WEST SUSSEX COUNTY COUNCIL CONSULTATION

TO:	Arun District Council FAO: Amber Willard
FROM:	WSCC - Highways Authority
DATE:	4 February 2020
LOCATION:	Bishop Tufnell C Of E Junior School, Pennyfields, Felpham, PO22 6BN
SUBJECT:	FP/251/19/PL Altering of existing west access to site to allow for vehicular access for emergency & maintenance purposes only. Drop kerb formed to allow for vehicular crossover, area to include a new area of secure bin storage for the school. fence off waiting area separating it from public access & existing vehicular entrance areas.
DATE OF SITE VISIT:	N/A
RECOMMENDATION:	Advice
S106 CONTRIBUTION TOTAL:	N/A

notes:

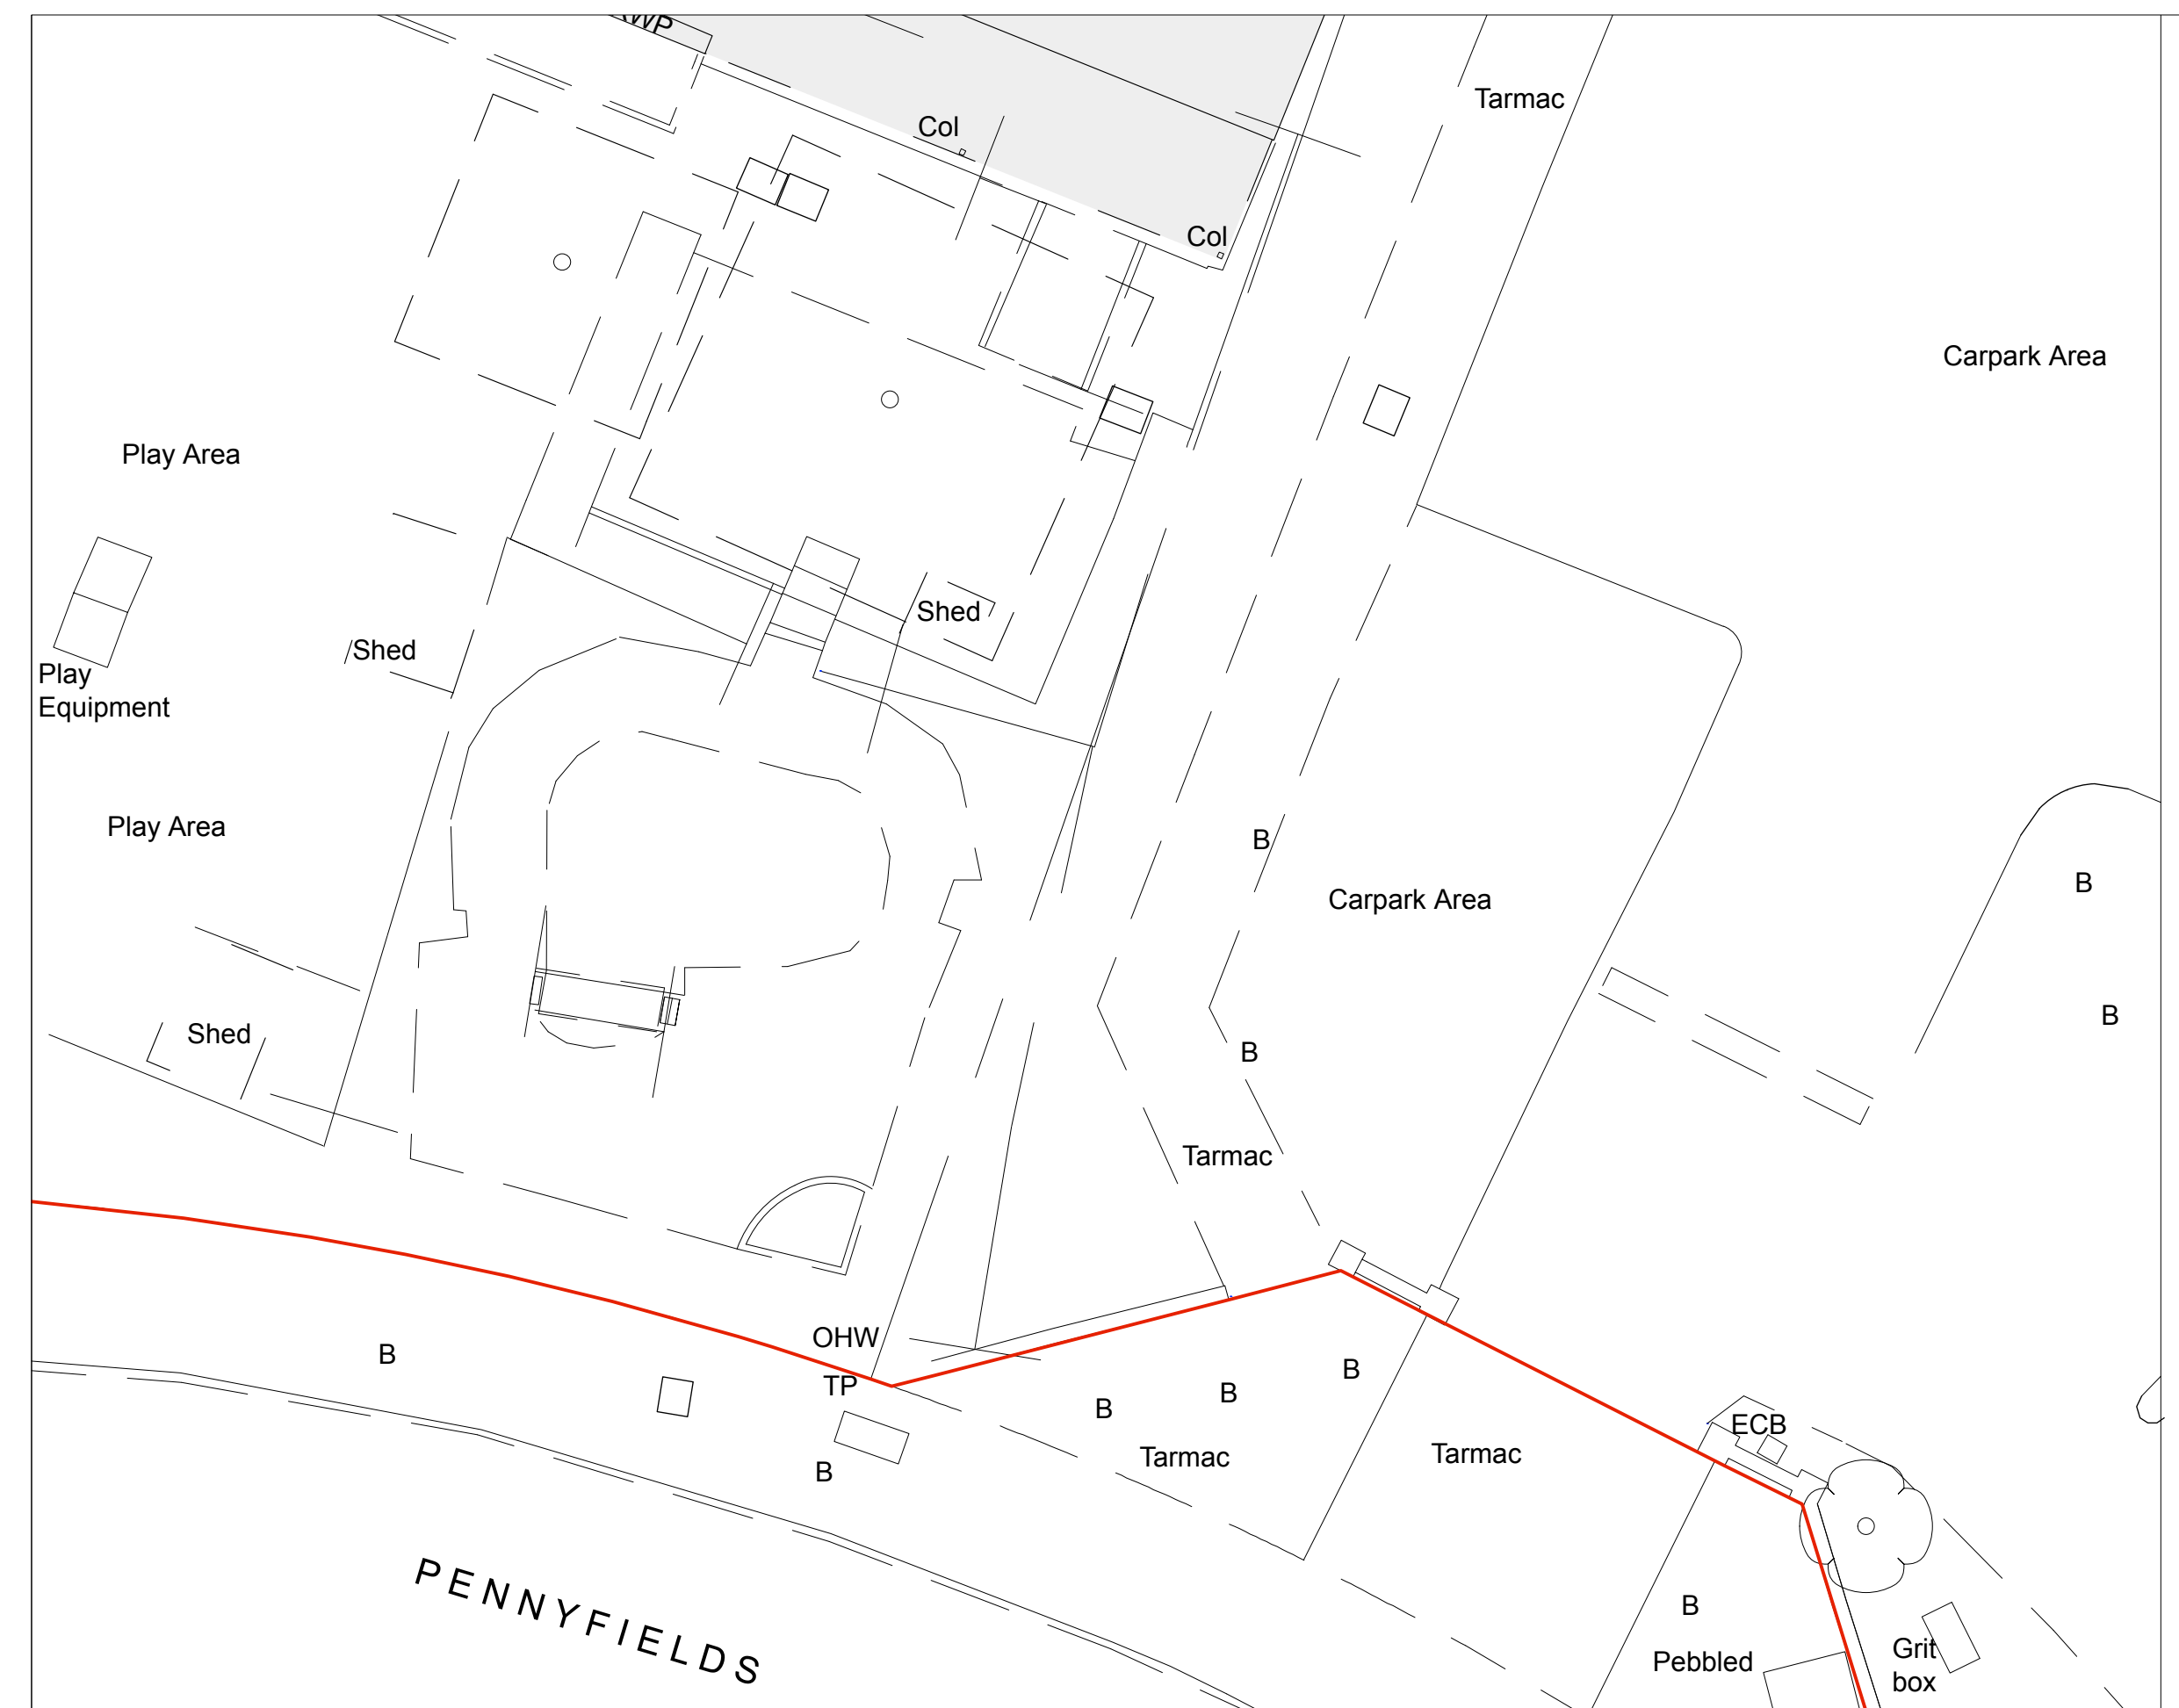
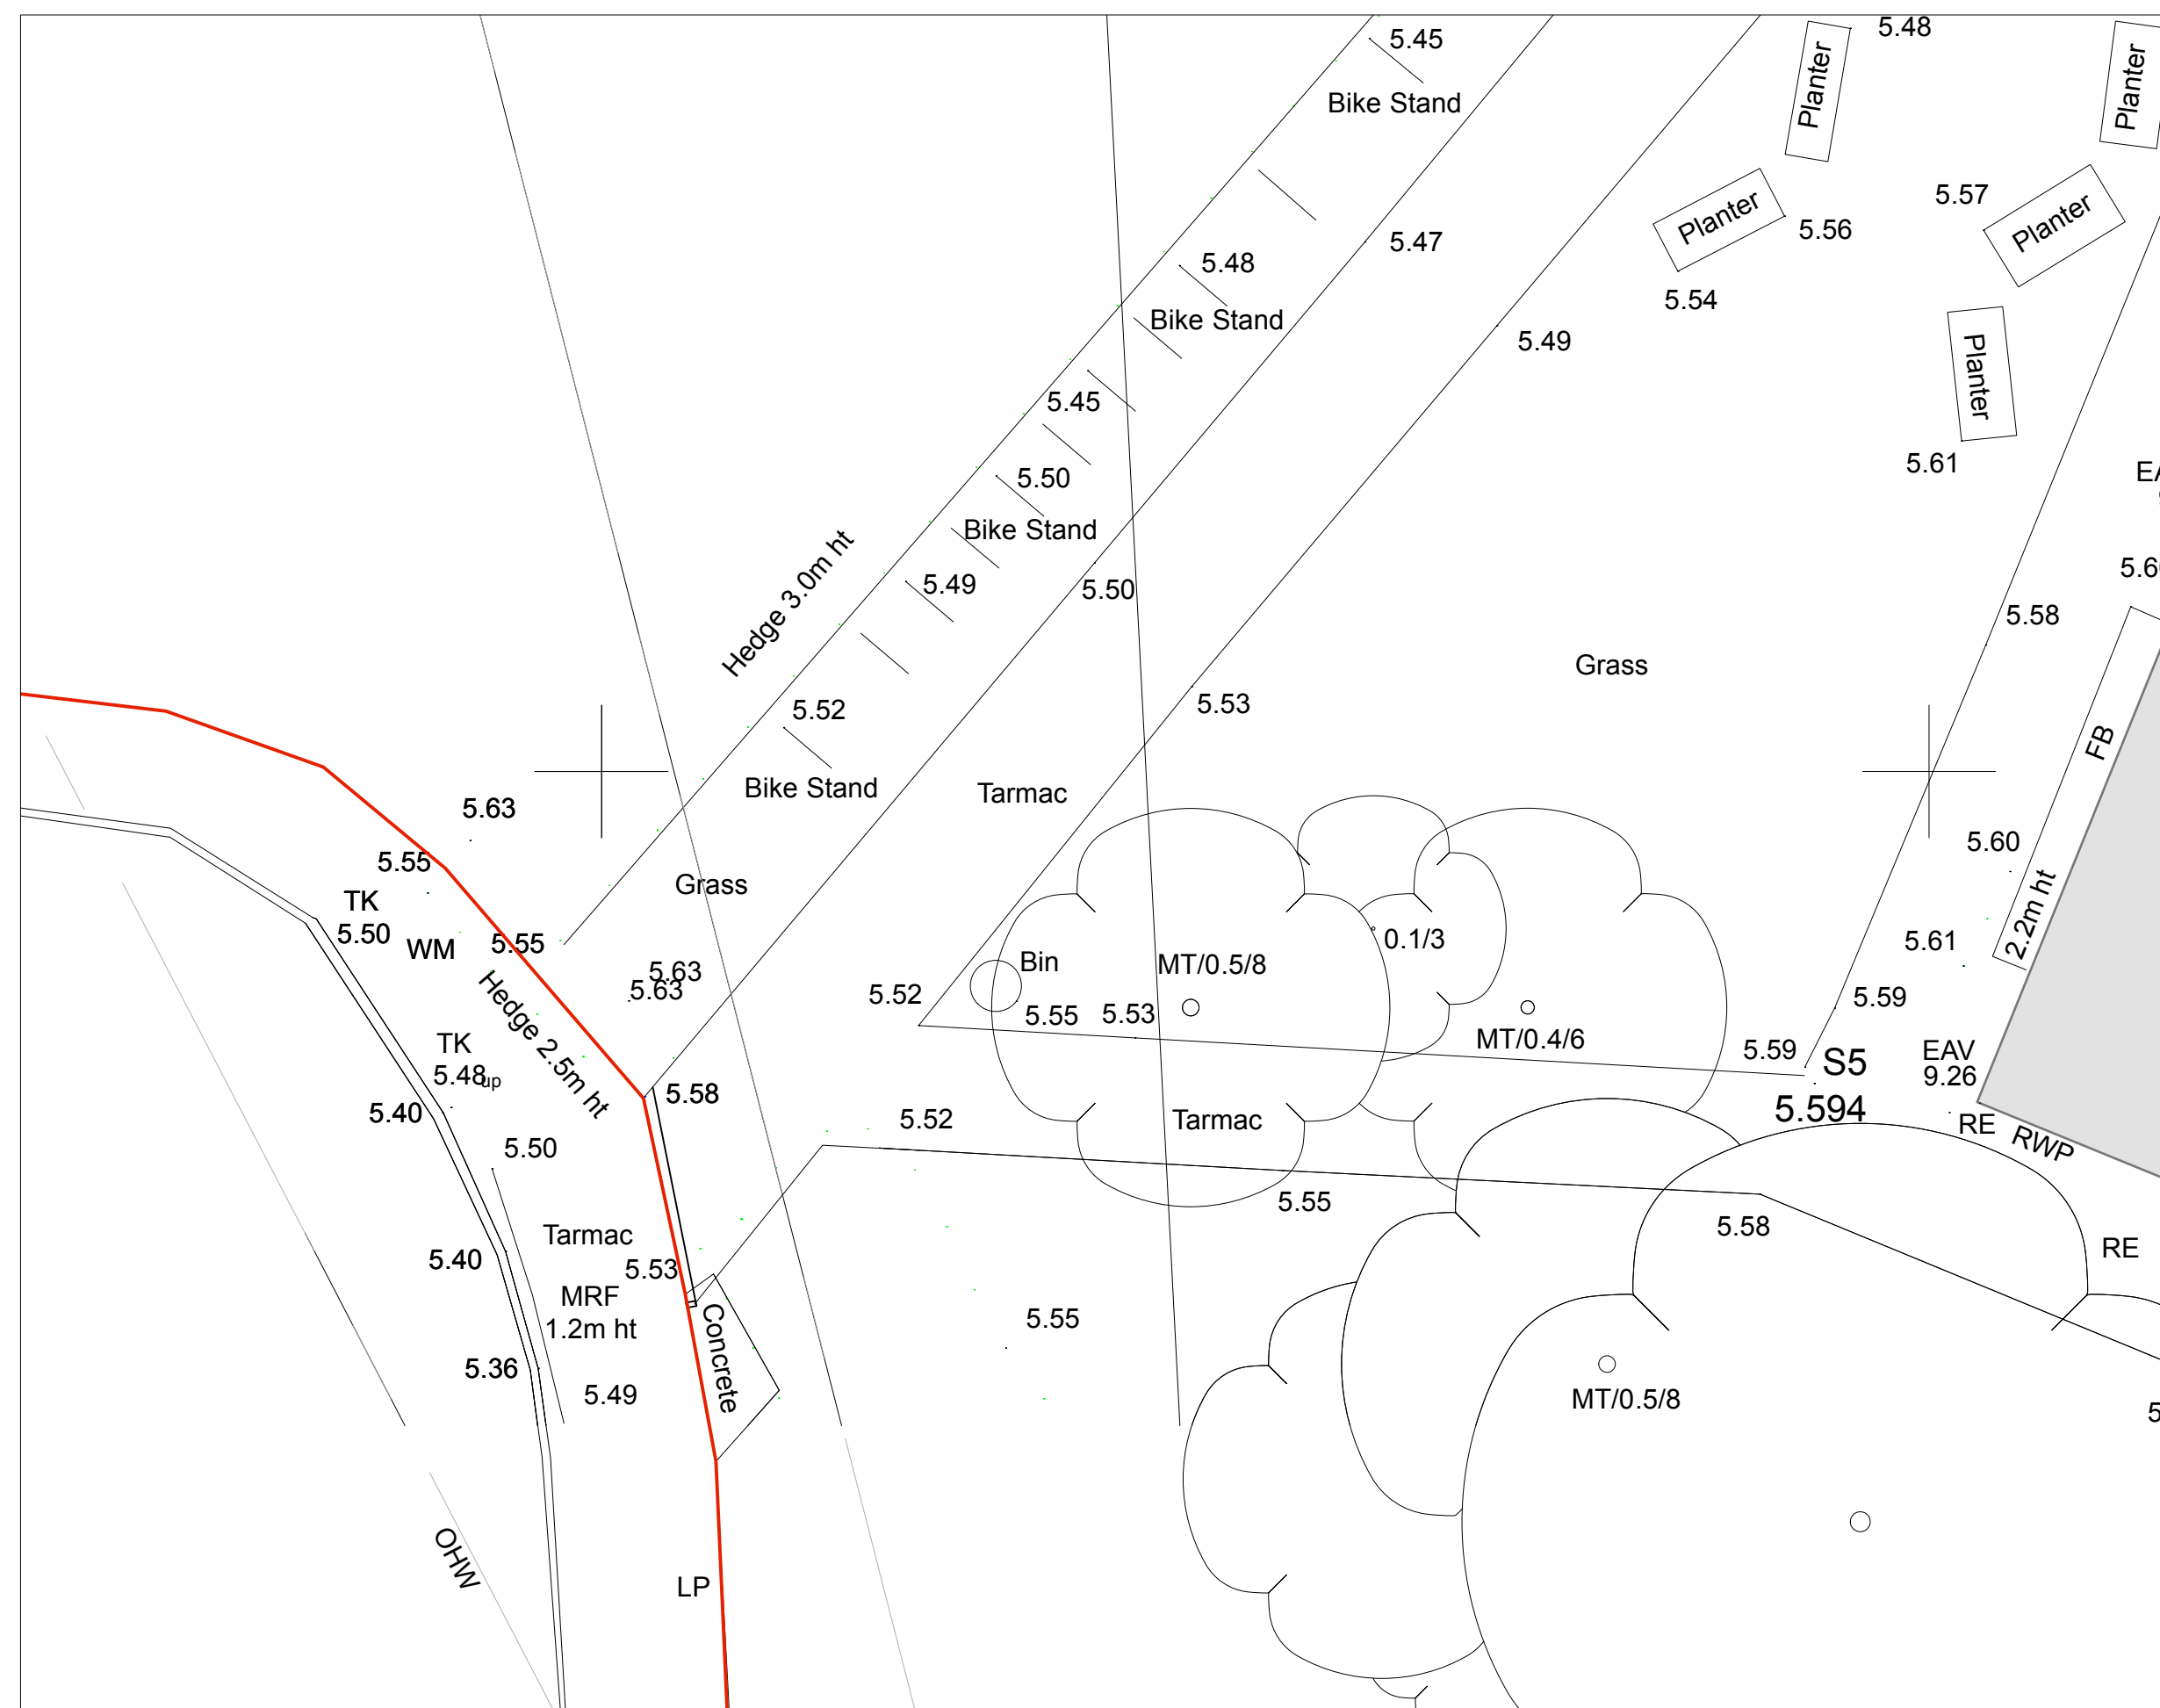
The existing early years drop off/pick up area to the east of the site is to be fenced off. From inspection of local mapping, the proposed segregation would result in the loss of four existing car parking spaces. The plans suggest that these parking spaces will not be replaced. As such, parking would have to be accommodated elsewhere on site, or on-street.

The existing pupil access point to the west of the site is to be altered to form a vehicular access for emergency and maintenance purposes only. The proposed works will require a dropped kerb, which is subject to a licence obtained through the local area office. The vehicle crossover (VCO)

would be constructed to a specification agreed with the local area engineer. The works will also require the removal of the pedestrian guard railing in this location.

There are no apparent vehicular visibility issues at the proposed access. However, the LHA requests that boundary hedging for two metres either side of this access point (and two metres within the site) is replaced with railings or similar to ensure maximum pedestrian visibility is provided in this location.

No part of the development shall be first occupied until pedestrian visibility splays of 2 metres by 2 metres have been provided either side of the proposed site vehicular access onto Pennyfields in accordance with plans and details to be submitted to and approved in writing by the Local Planning Authority. These visibility splays shall thereafter be kept free of all obstructions over a height of 0.6 metre above adjoining carriageway level or as otherwise agreed.
